Office of Environment & Heritage

Re: Response to Submissions, Altitude Aspire Residential Subdivision (MP 09_0166 MOD 3), Terranora Tweed LGA

Enclosure: Attachment 1: Detailed OEH Comments – Response to Submissions (RtS) for the Altitude Aspire Residential Subdivision MP 09_0166

NEWLAND DEVELOPERS PTY LTD	09-374 16-11-2017
TERRANORA PRECINCT 1 WEST BOUNDARY EARTHWORKS EXTENT	SK 6524 REVISION A

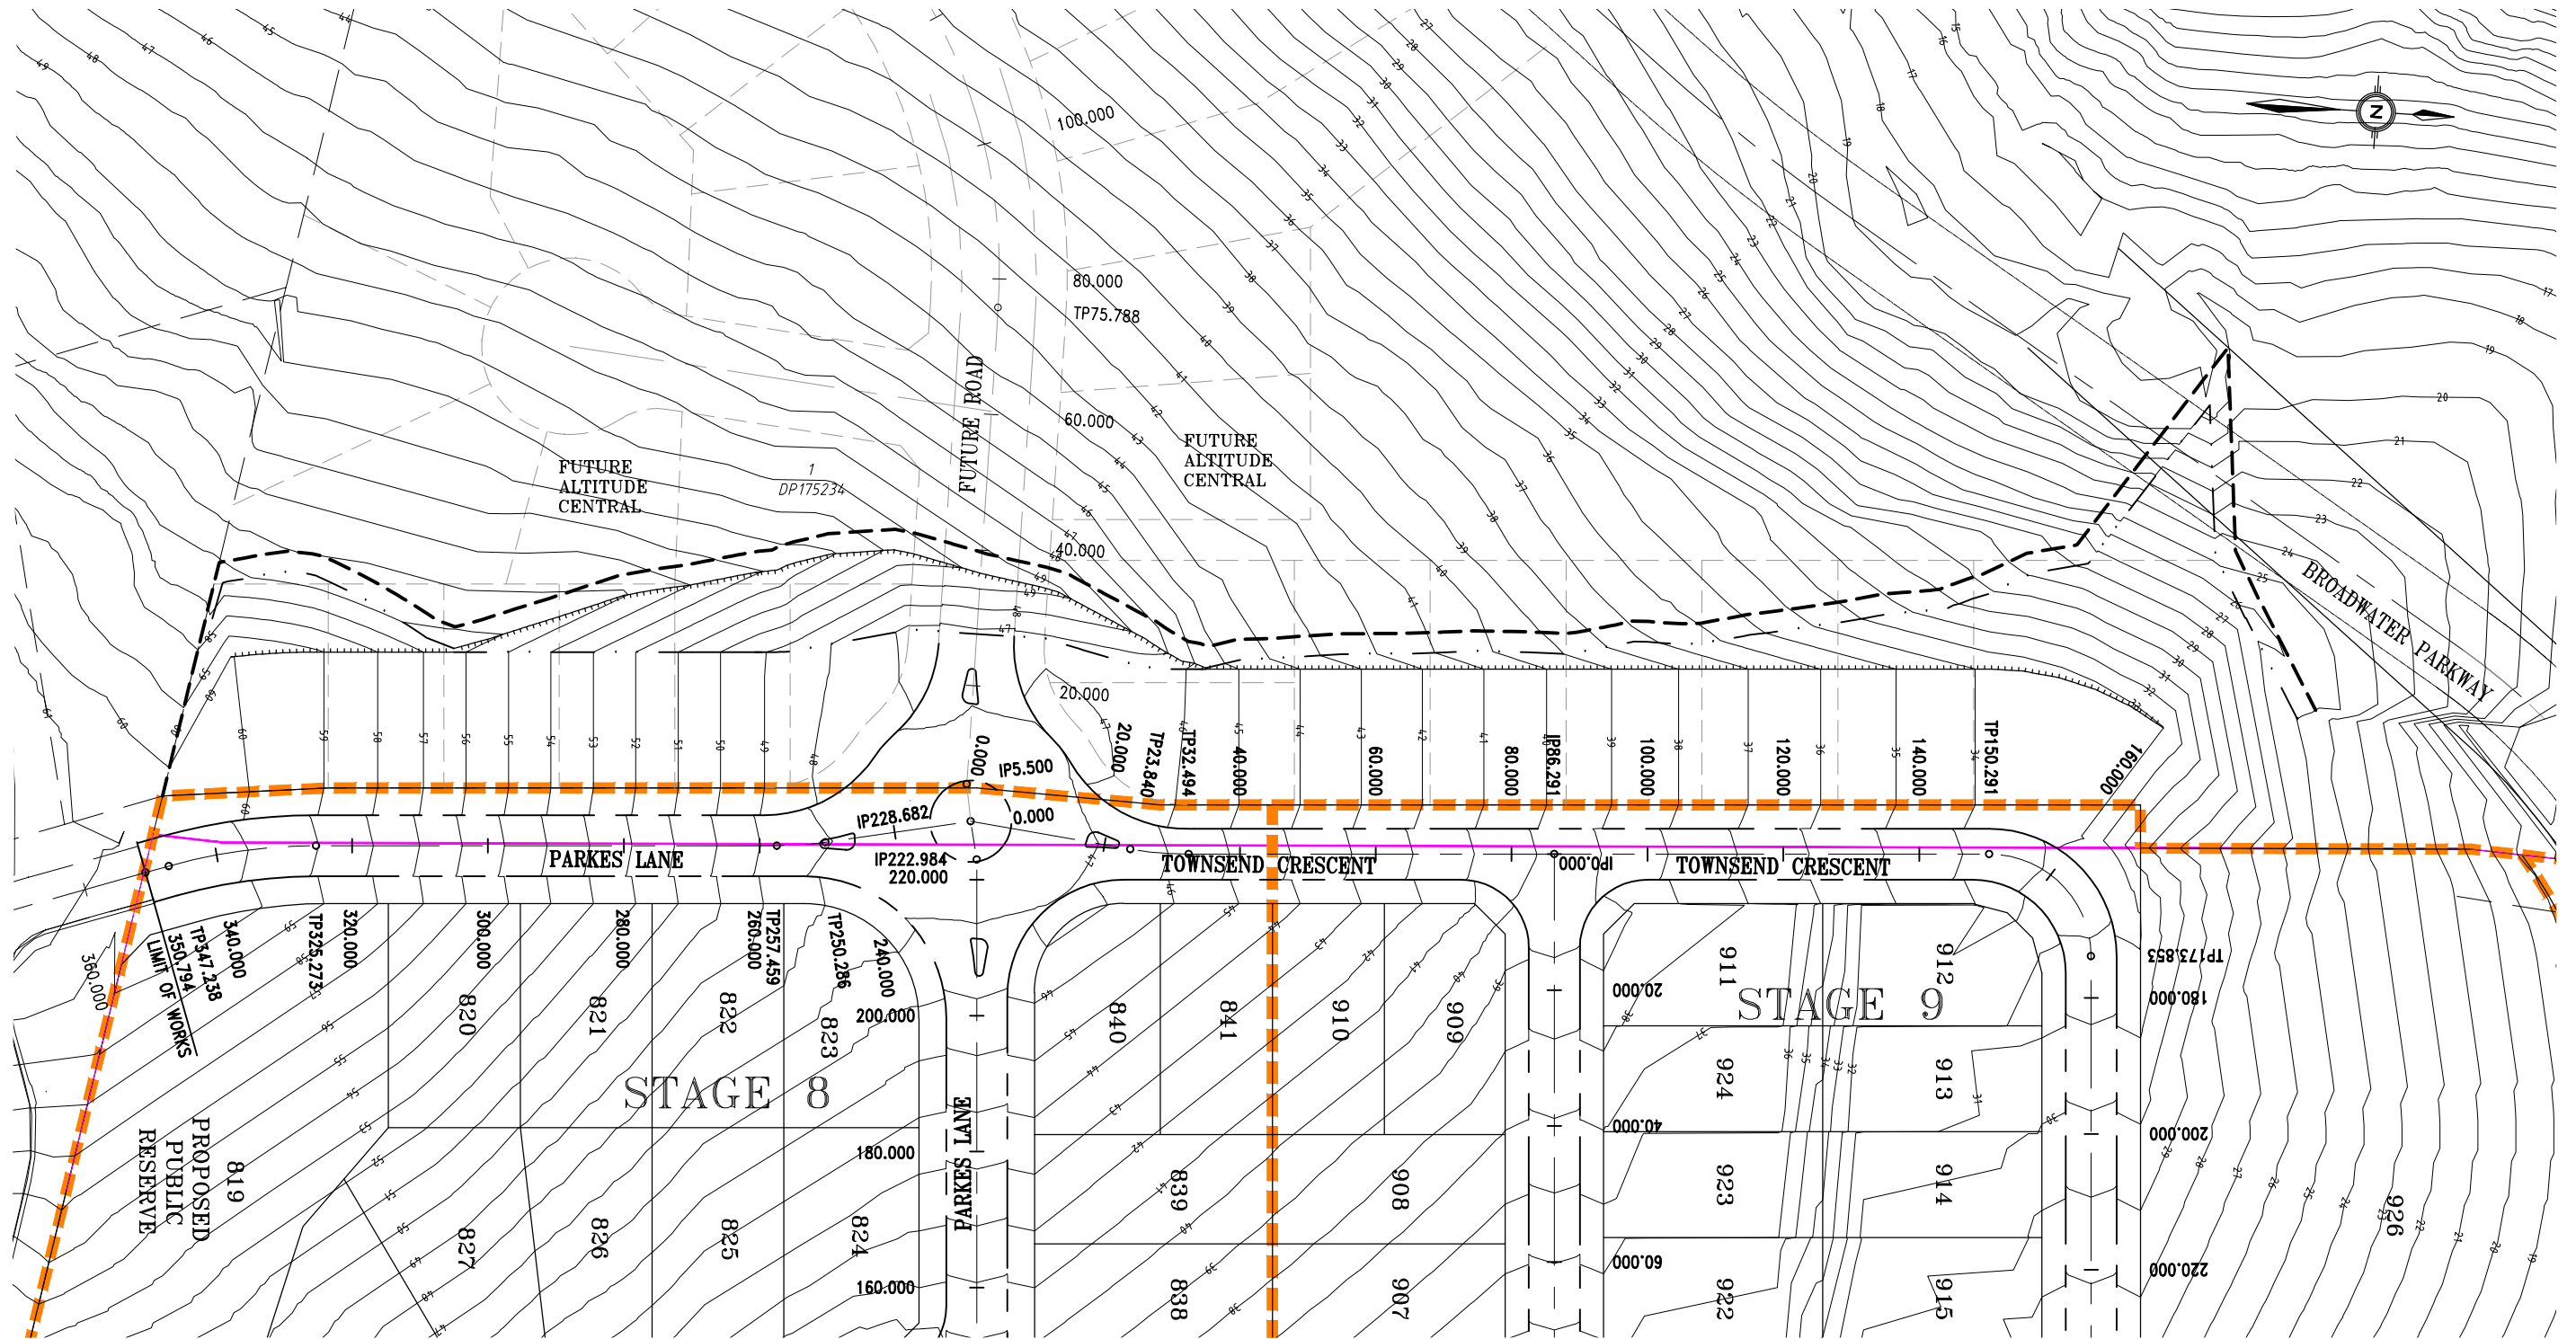
The OEH previously raised the issue of whether the proposal could be considered given the works are on the adjoining Lot 1 DP 175234 that was not part of the 'subject site' for the Part 3A project. The Department of Planning and Environment (DPE) has advised that it considers the works on the adjoining property can be considered within the scope of a Part 3A Modification.

The EA states that the proposed development does not trigger the clearing threshold for the Biodiversity Offset Scheme (BOS). This conclusion appears to be founded on an assumption that vegetation mapped as Vegetation Association A is not vegetation for the purposes of the BAM and BOS. It maps the vegetation on Lot 1 DP 175234 in the area to be impacted by the bulk earthworks as Type A Tall Closed Forest (*Cinnamomum camphora*). The previous OEH advice referred to the species list in Table 5.4 for the Type A Tall Closed Forest (*Cinnamomum camphora*) which indicated some species were consistent with the *Lowland Rainforest in the NSW North Coast and Sydney Basin Bioregions* endangered ecological community (EEC).

The OEH does not agree with the conclusion that the development does not trigger the clearing threshold. The assessment of the proposed cut and fill in Lot 1 DP 175234 should be undertaken in accordance with the BAM.

1. The ecological assessment of the impacts arising from the proposed cut and fill works and any other development in Lot 1 DP 175234 should be assessed in accordance with the Biodiversity Assessment Method by an accredited assessor and a Biodiversity Development Assessment Report prepared.
